**Colorado Springs Airport Advisory Commission Meeting
To Be Heard February 27, 2019
Land Use Review Item #13**

EL PASO COUNTY BUCKSLIP NUMBER(S): PPR-19-003 COMMERCIAL DEVELOPMENT PLAN		TAX SCHEDULE #(S): 5407317012
DESCRIPTION: Request by Associated Design Professionals on behalf of Copestone General Contractors for approval of a site development plan for Appaloosa Highway 24 Subdivision Filing No. 1A Lot 2. The plan is for construction of a 10,800 square foot light industrial building. The site is zoned I-2 (Limited Industrial) and consists of 1.08 acres. The property is located northeast of Platte Avenue and Powers Boulevard. <i>Review Note: A vacation and replat to subdivide Lot 2 of Appaloosa Highway 24 Subdivision into three lots and allow a mobile home sales office was reviewed and approved by the Commission in August 2018.</i>		
CONSTRUCTION/ALTERATION OF MORE THAN 200 FEET ABOVE GROUND LEVEL? No	DISTANCE/DIRECTION FROM COS: 5,570 feet north of Rwy 17R	
TOTAL STRUCTURE HEIGHT AT THE ESTIMATED HIGHEST POINT: 18 feet above ground level; 6,235 feet above mean sea level	COMMERCIAL AIRPORT OVERLAY SUBZONES PENETRATED: Accident Potential Zone 1 (APZ-1), Airport Noise Subzone (A

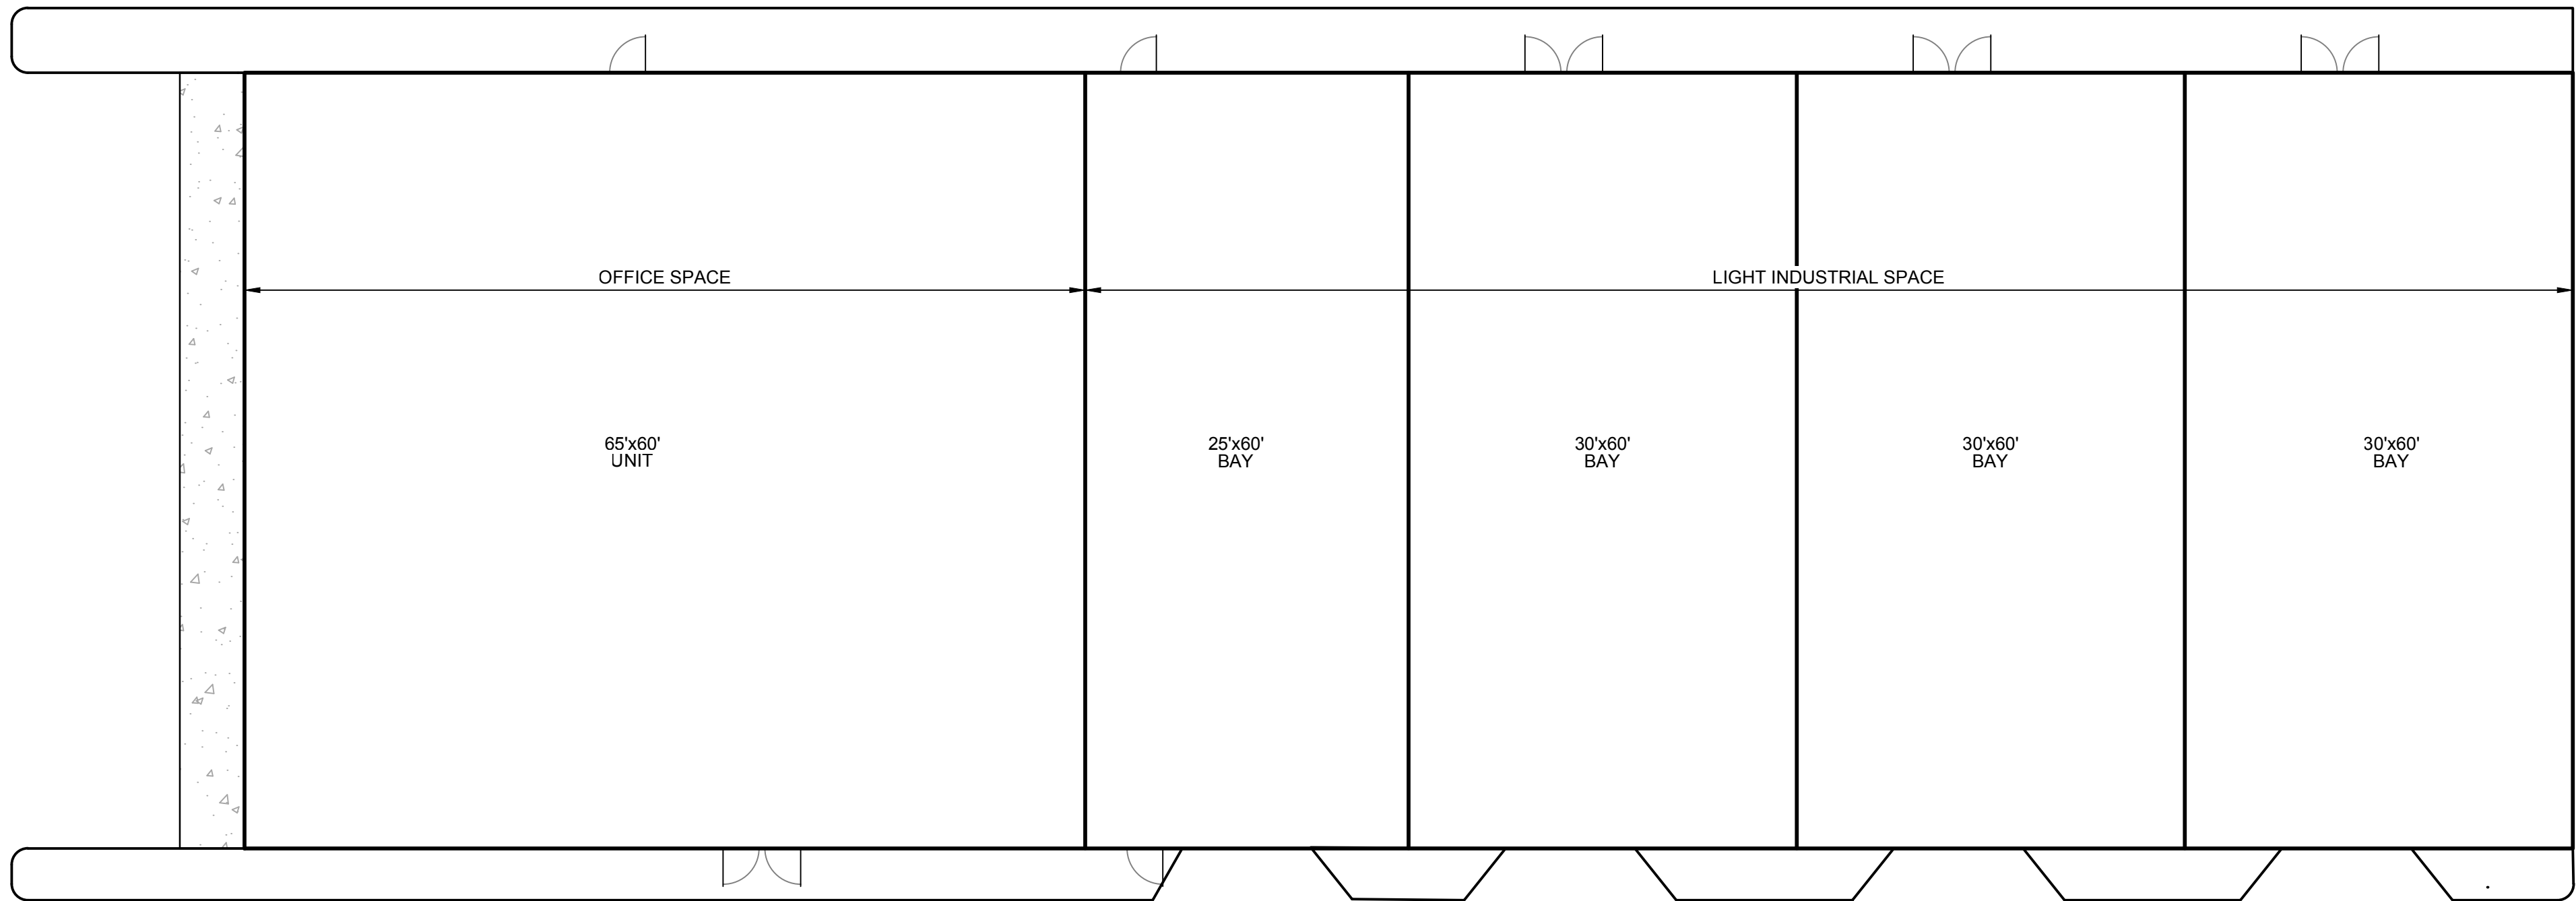
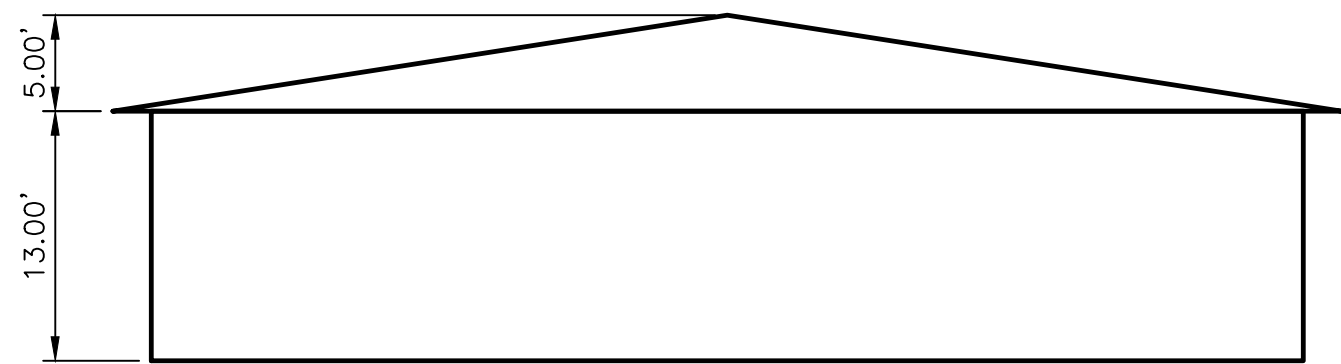
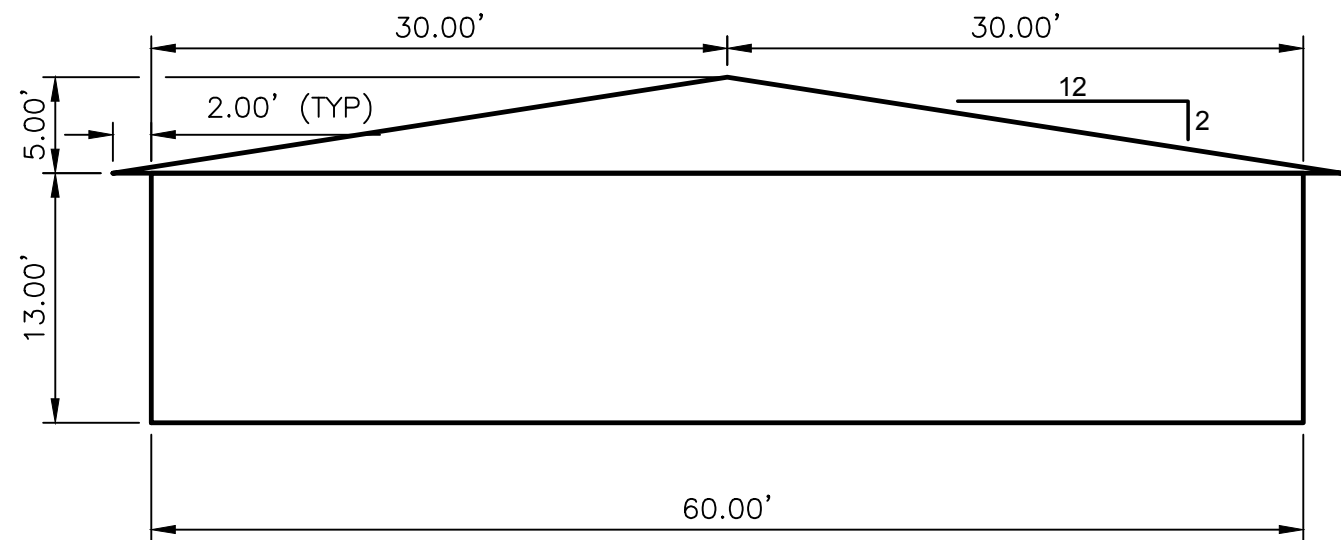
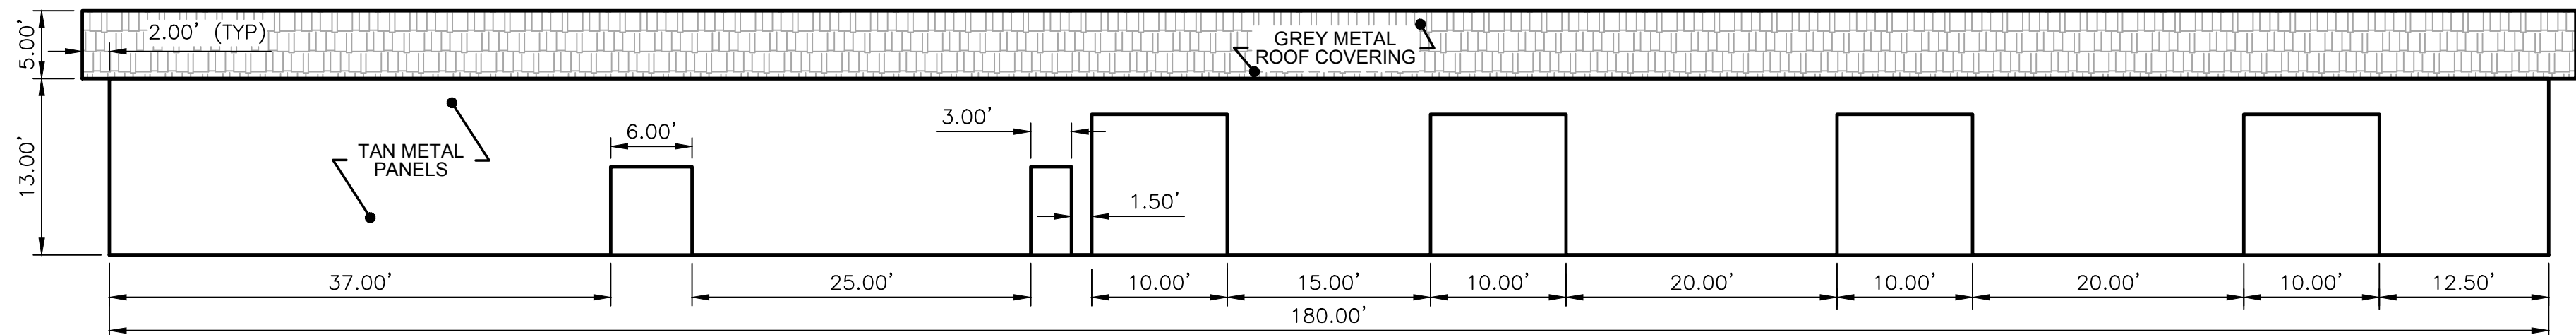
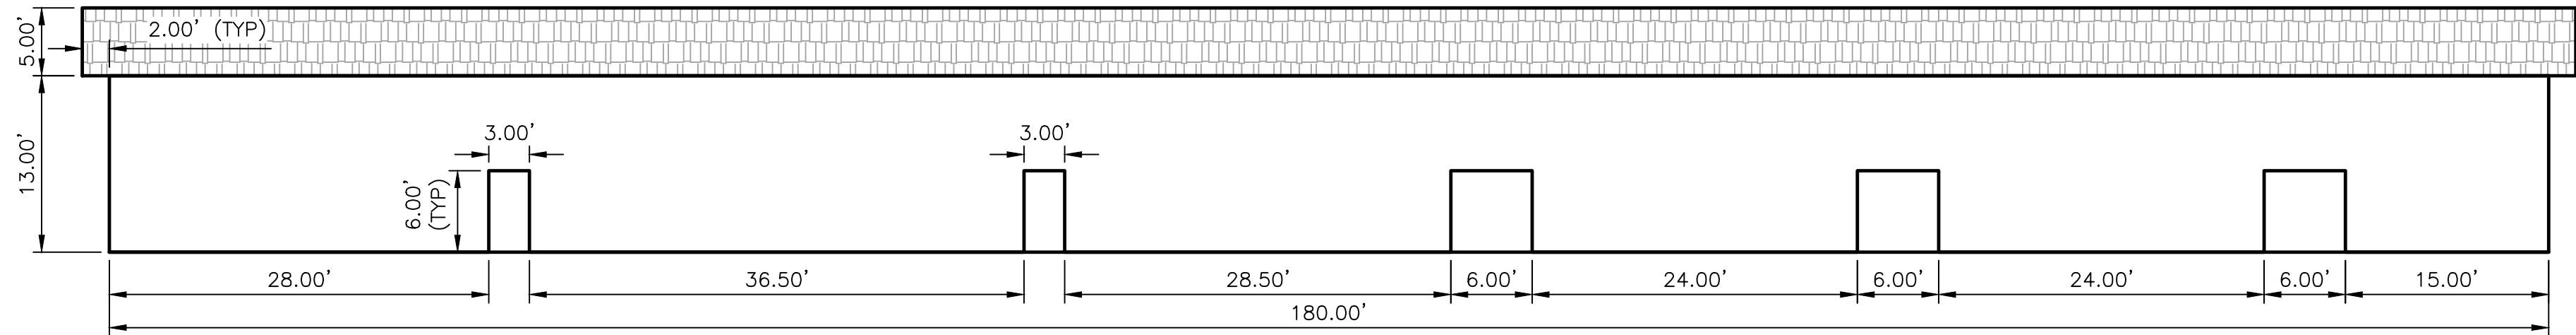
- The property is within the ADNL Airport Noise subzone of the Commercial Airport Overlay District, as adopted by El Paso County. The proposed use appears to be compatible within the ADNL; however, if there will be an office portion to the building, there is an indoor noise reduction requirement as outlined in Section 4.3.1 of the El Paso County Land Development Code.
